From: Zac Denton
Sent: 06 September 2017 15:16
To: [REDACTED]
Subject: EP/98/17/CLP

I was looking at the plans for your application EP/98/17/CLP and I think one of the scales may appear wrong. At the top of your plan (drawing number – 1104.02.a) it states that the scale for the elevations is 1:100. This would mean the extension is over 6m high!

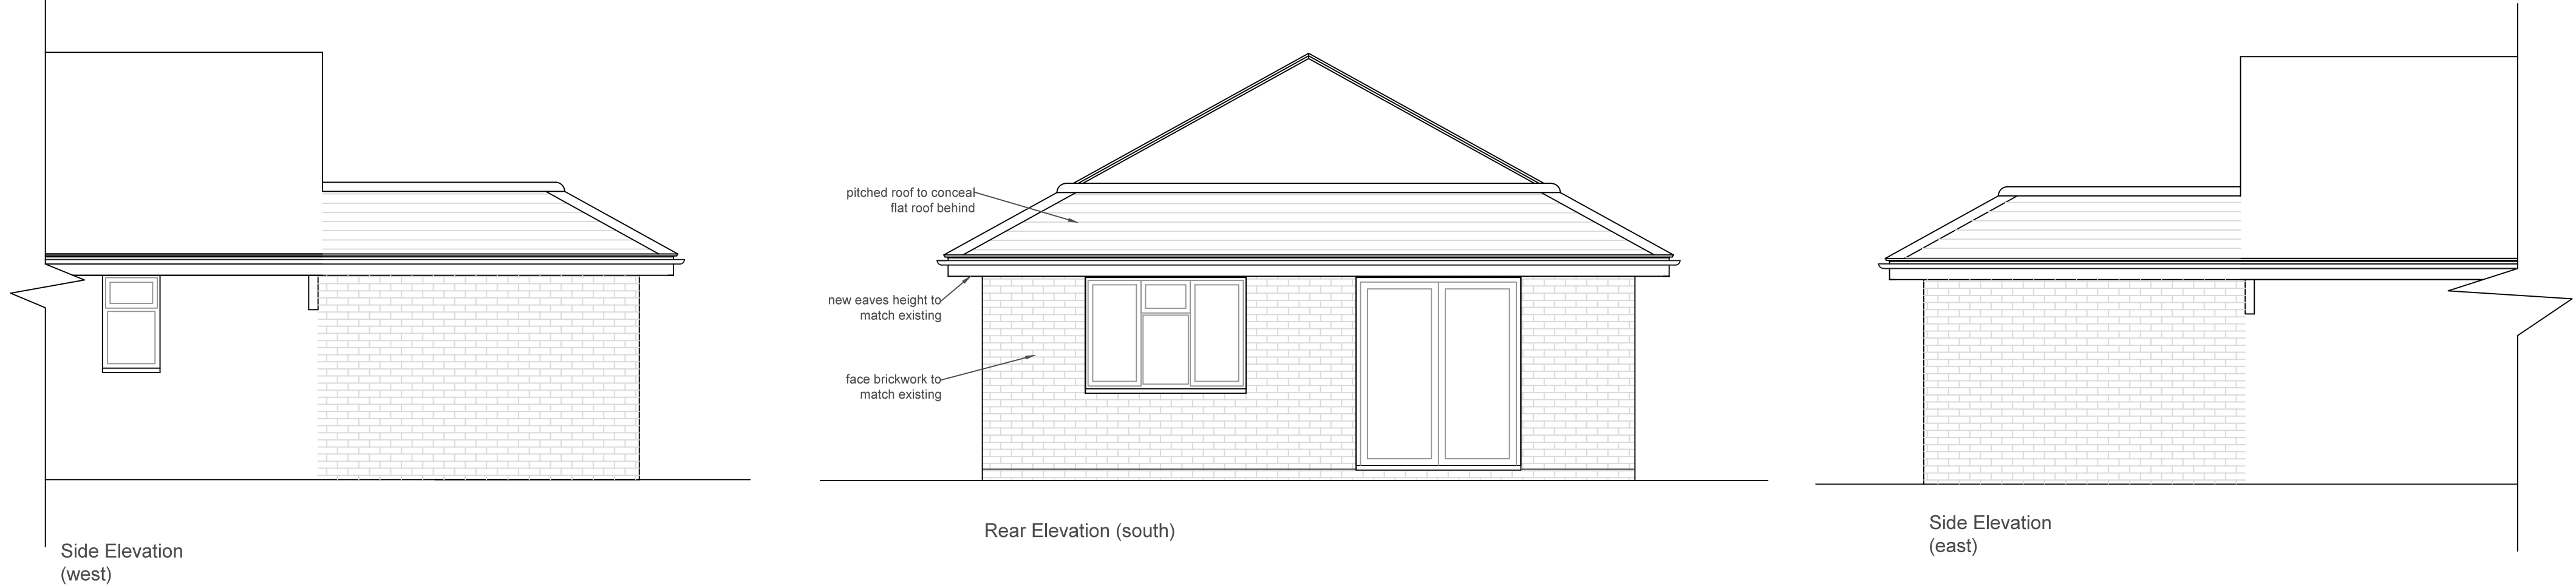
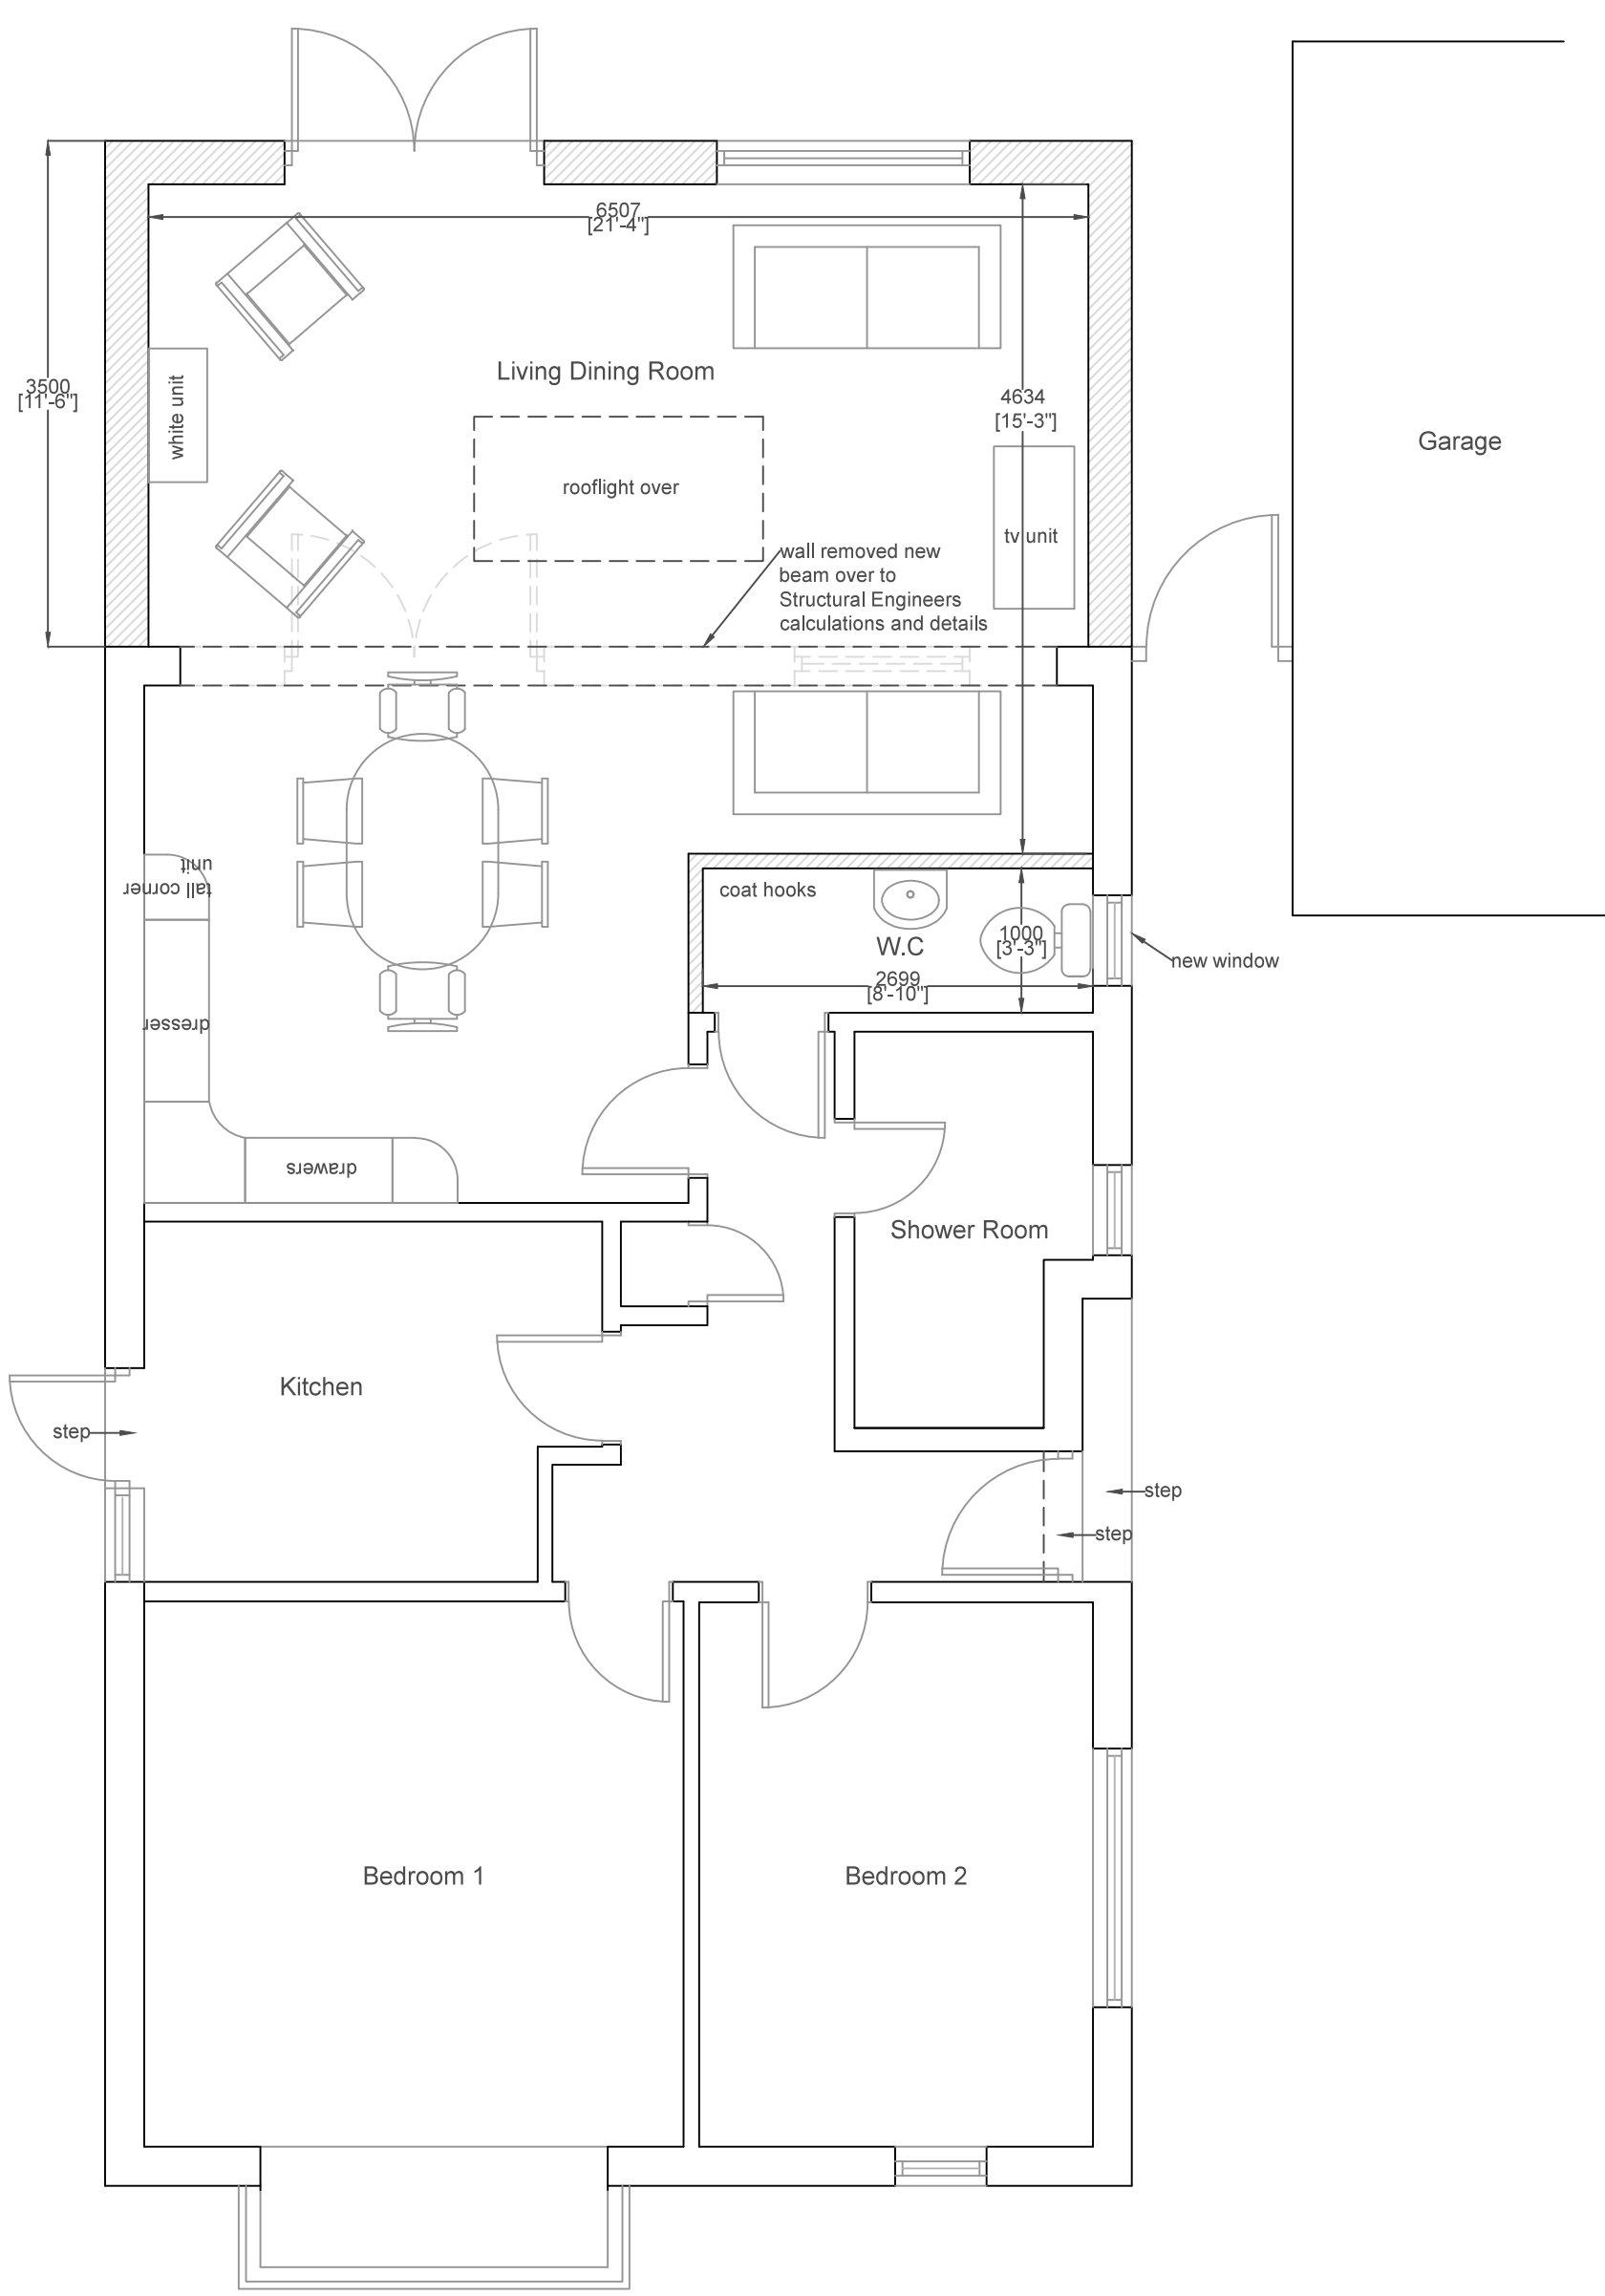
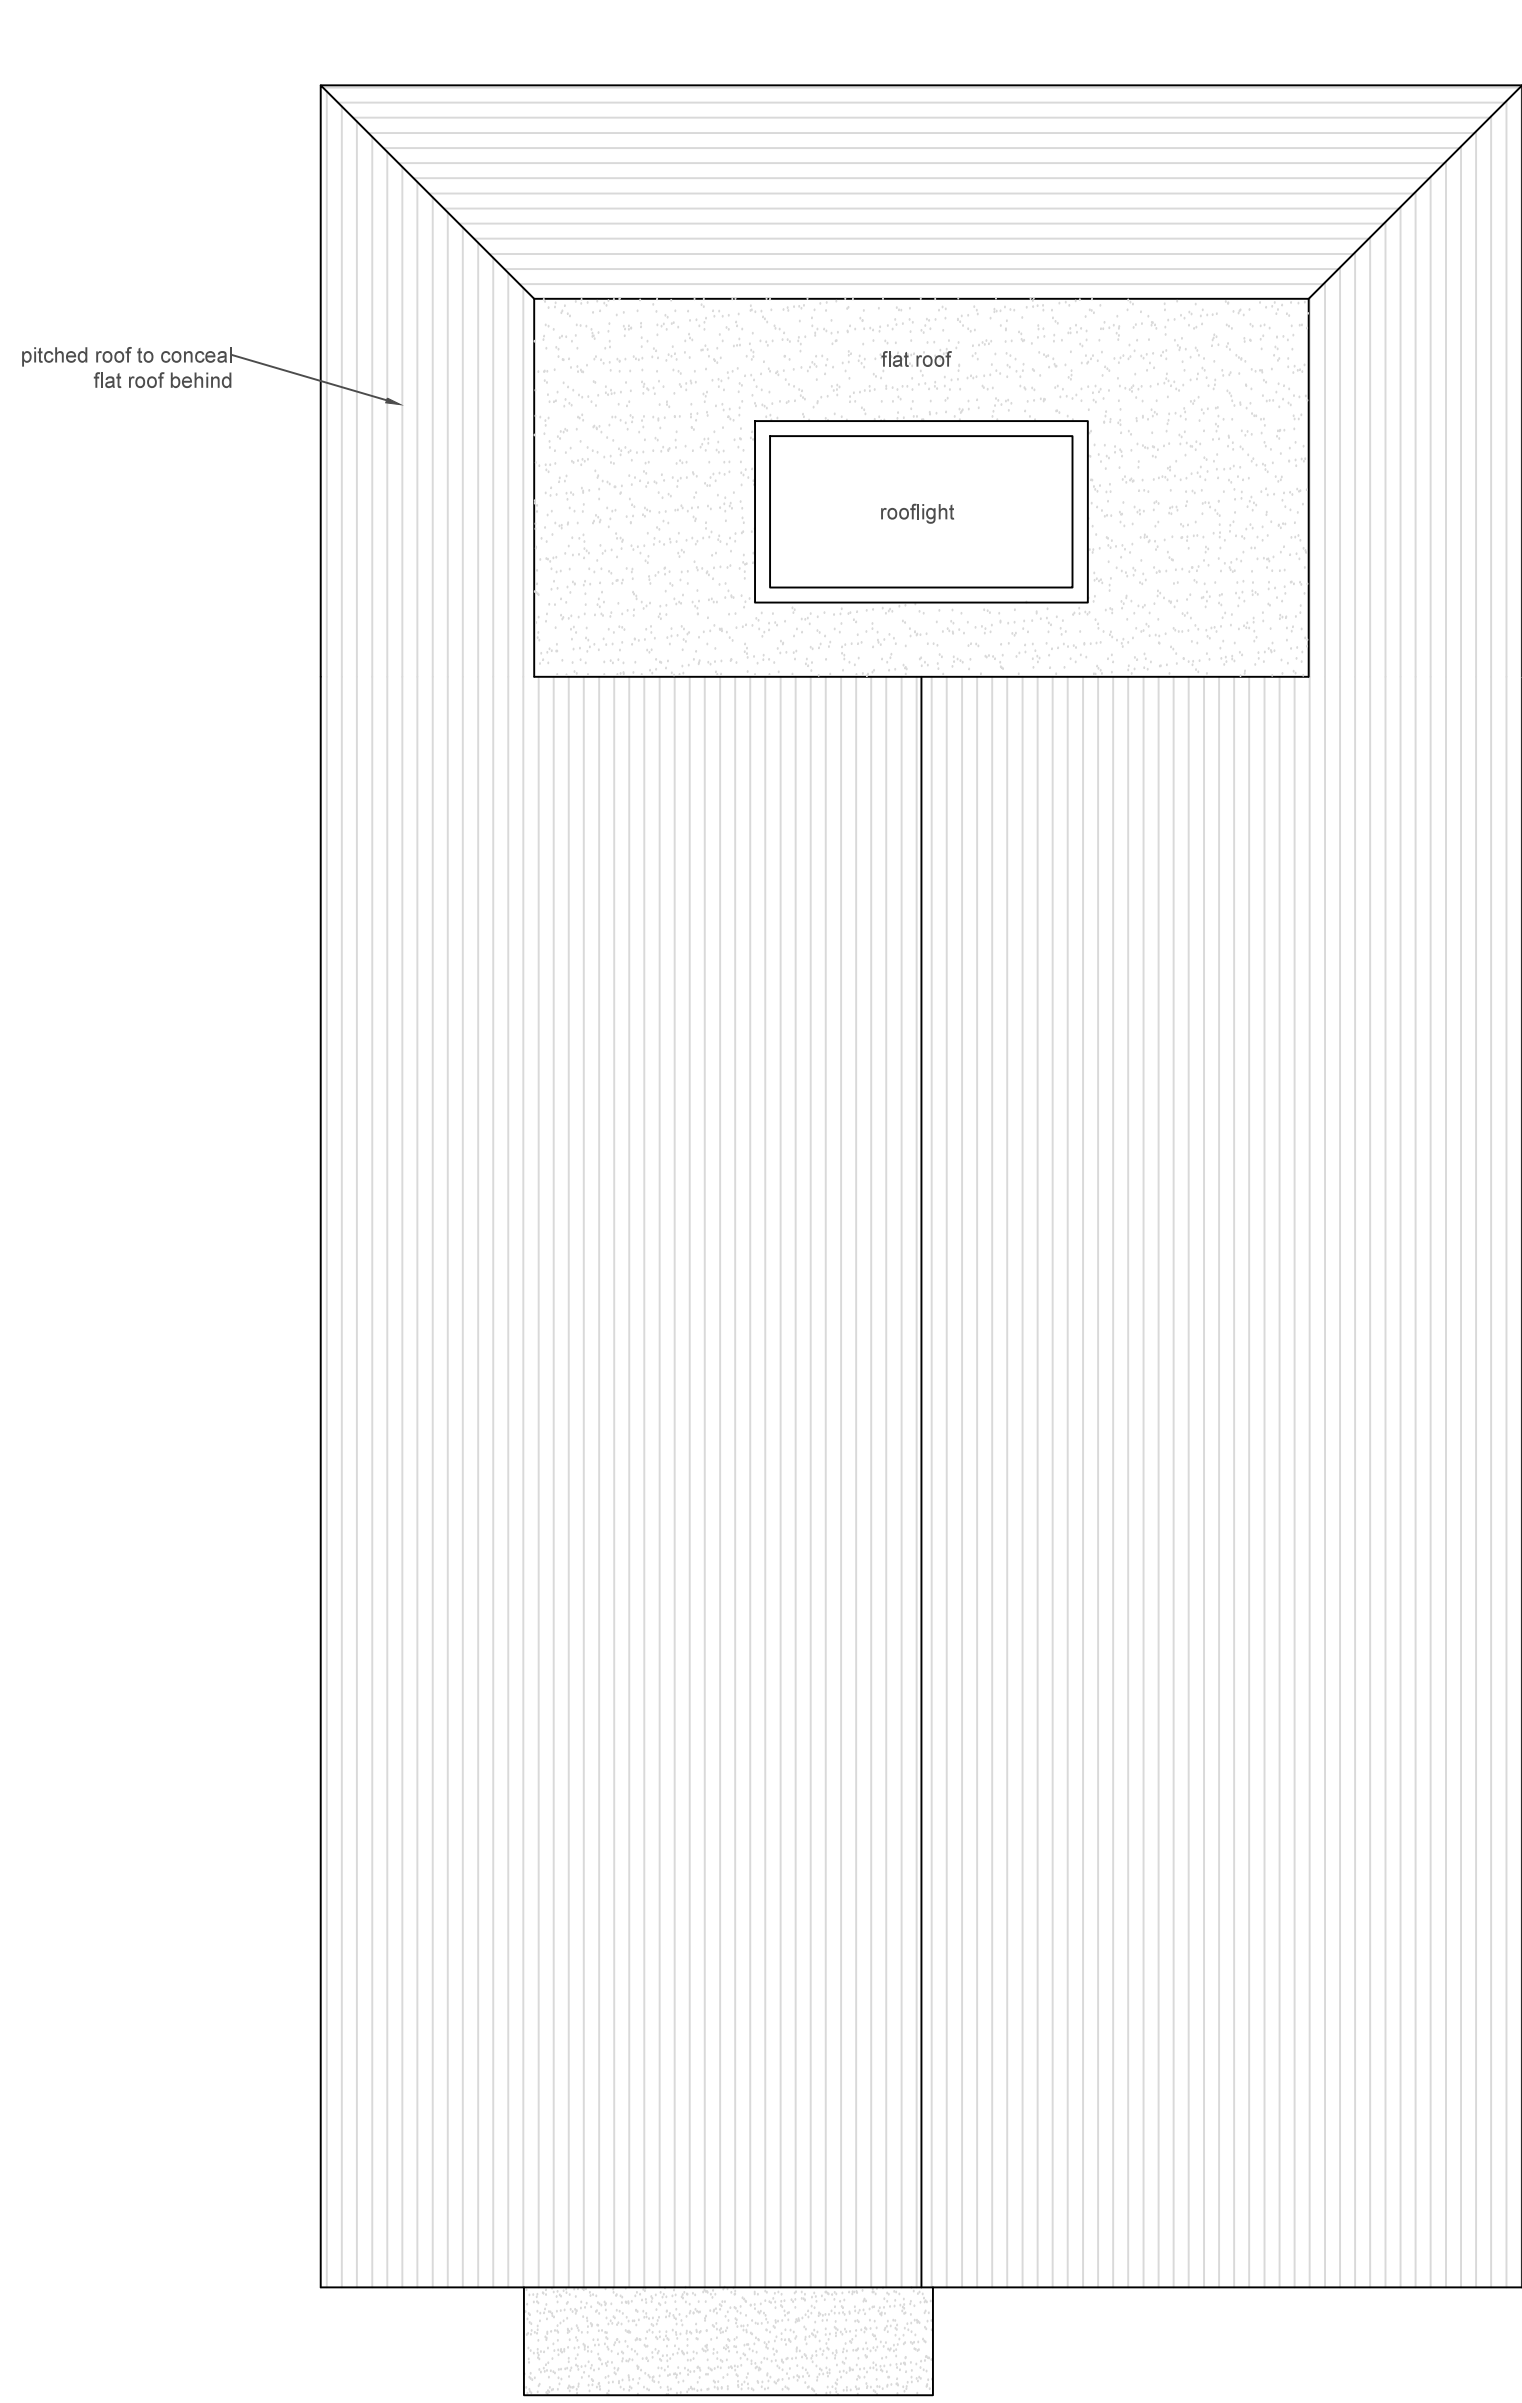
If it is incorrect then please reply to this email with an amended plan. (I feel as if the correct scale may be 1:50)
